Application by London Luton Airport Limited for an Order granting development consent for the London Luton Airport Expansion project: Response to advice received from the Planning Inspectorate under section 51 of the Planning Act 2008

The Applicant has updated a number of application documents in response to the section 51 advice and now provides this updated documentation for the Inspectorate's consideration. Table 1 below sets out how each particular aspect of the section 51 advice has been addressed.

Figure 9.1: Community First zone

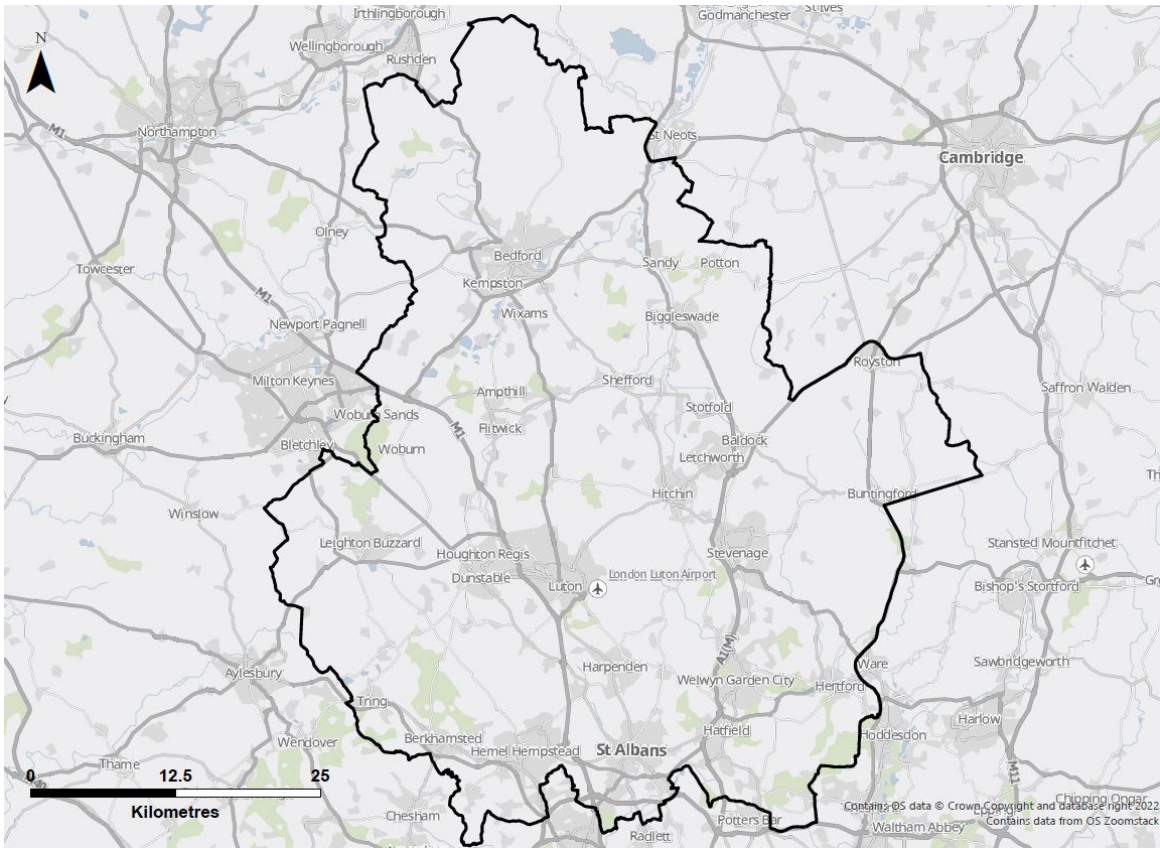
A minor amendment has been made to the Draft Compensation Measures, Policies and Community First document [TR020001/APP/7.10] to correct the eastern boundary of the Community First zone shown on Figure 9.1. This amendment is required to ensure the figure accurately depicts the zone as described in the associated text within this document.
